**KIRKLEES METROPOLITAN COUNCIL
INVESTMENT & REGENERATION SERVICE**

DELEGATED DECISION TO DETERMINE PLANNING APPLICATIONS

Reference No:	2025/62/90970/W
Site Address:	384, Wakefield Road, Dalton, Huddersfield, HD5 8DY
Description:	Erection of two storey side extension with balcony to rear elevation and associated alterations
Recommending Officer:	Elenya Jackson

OFFICER REPORT

Drawing Title:
Proposed Elevations

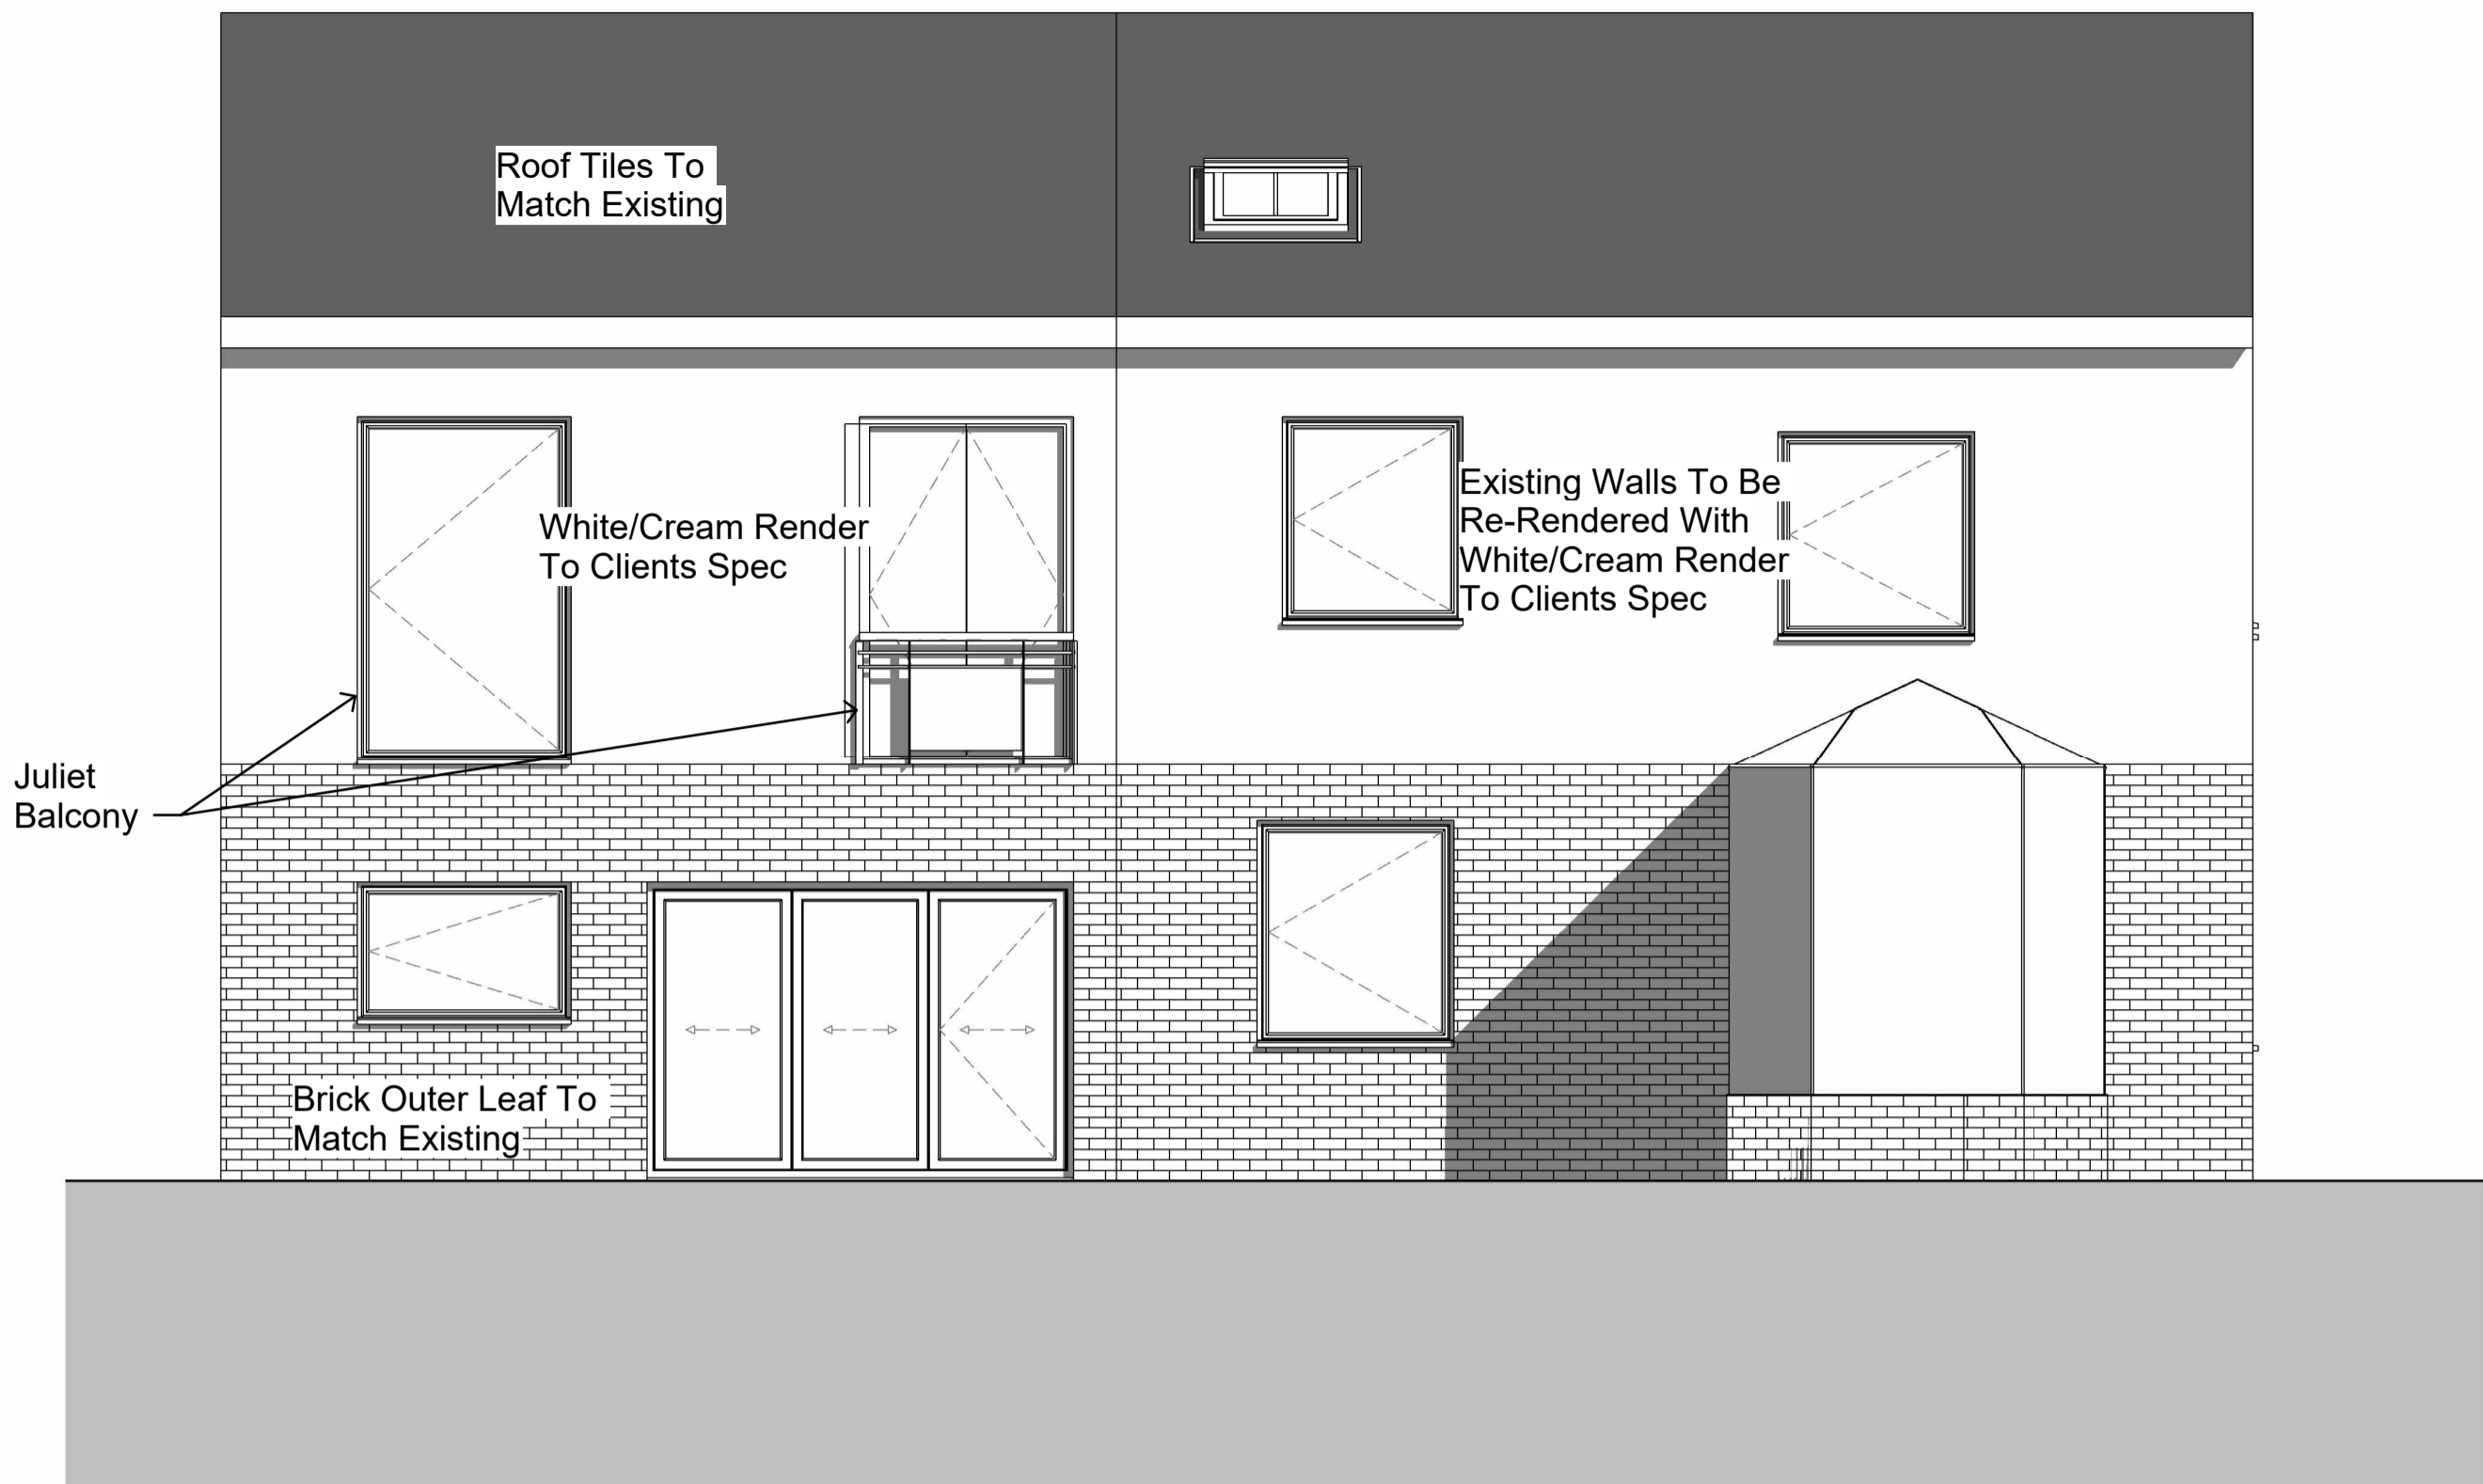
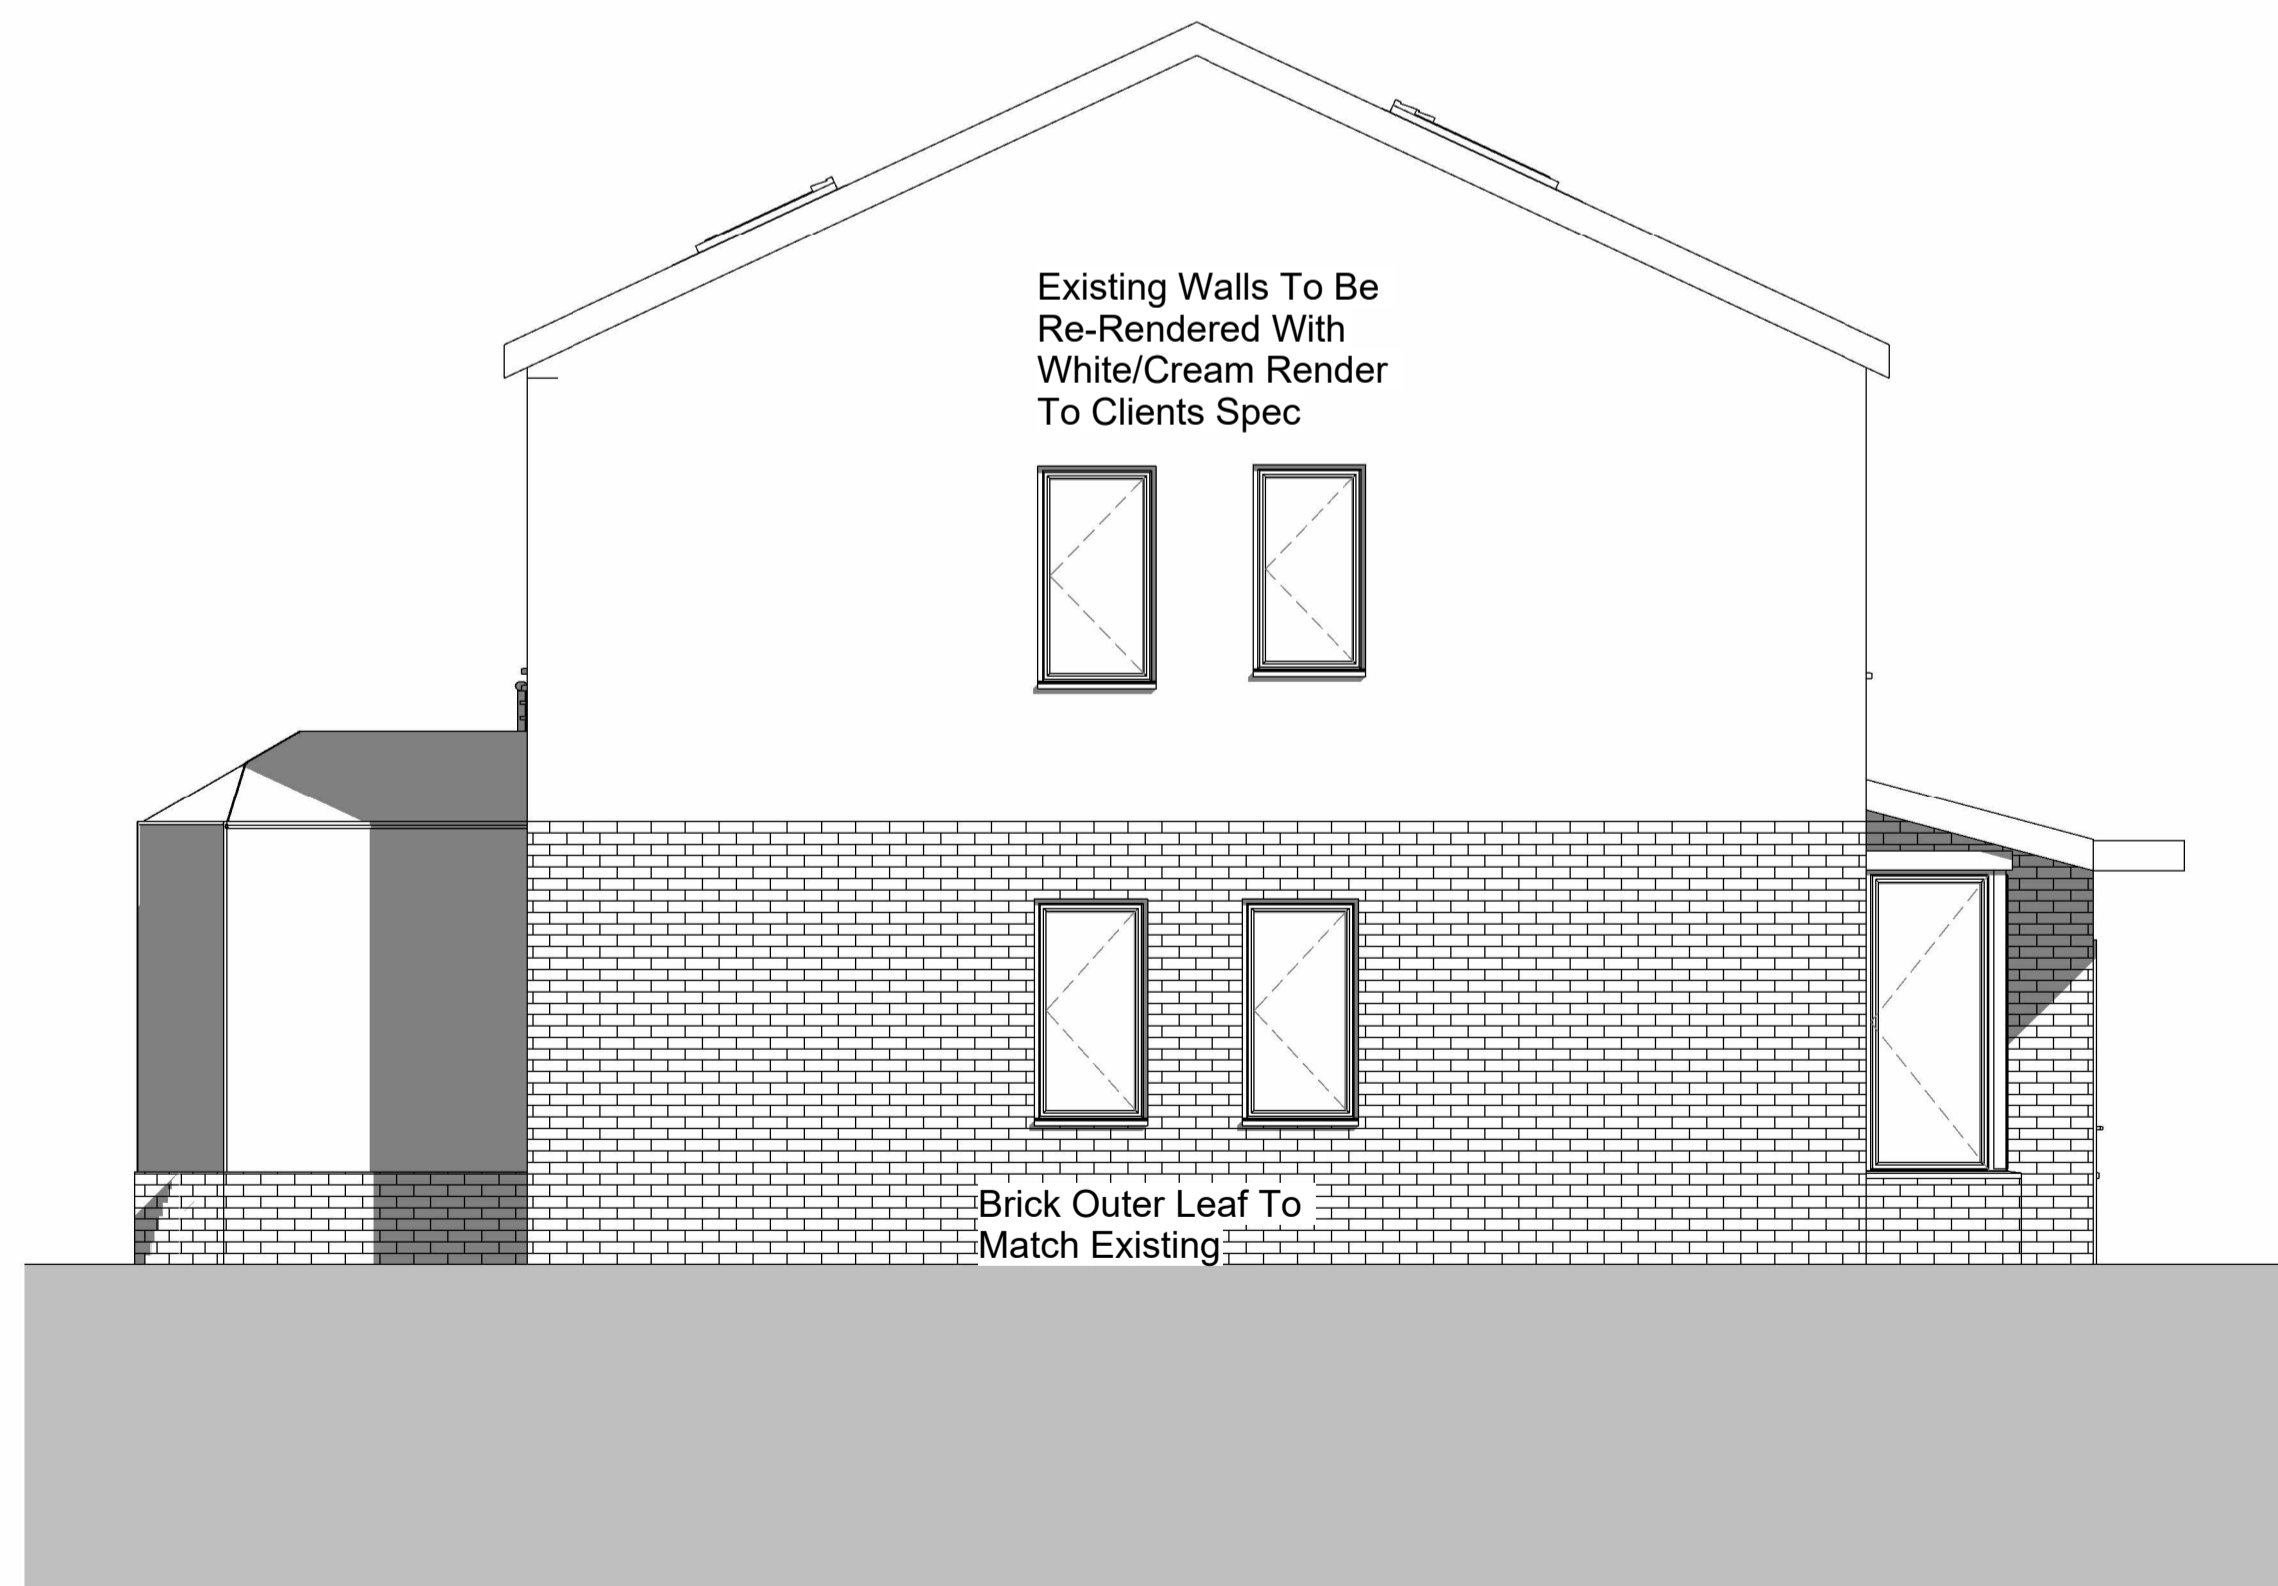
Officers note that the proposal would be flush with the front elevation of the existing dwelling; however, there is not a uniform design within the street scene and due to the spacing with adjoining neighbours, the property largely appears as a stand alone building.

The proposal would retain a gap of more than 1m from the shared boundary as required by the SPD, and therefore would not significantly impact spacing in the street scene.

The proposal would result in alterations to the external appearance of the dwelling as a whole, by introducing render. Officers consider that as there are examples of render in the vicinity and as the properties that form the street scene are not uniform, the alterations to the dwelling would be acceptable in this instance.

Overlooking: The proposal would feature rear facing windows; however, these would not extend closer to no.3 than the host dwelling and would therefore continue the existing relationship between the properties.
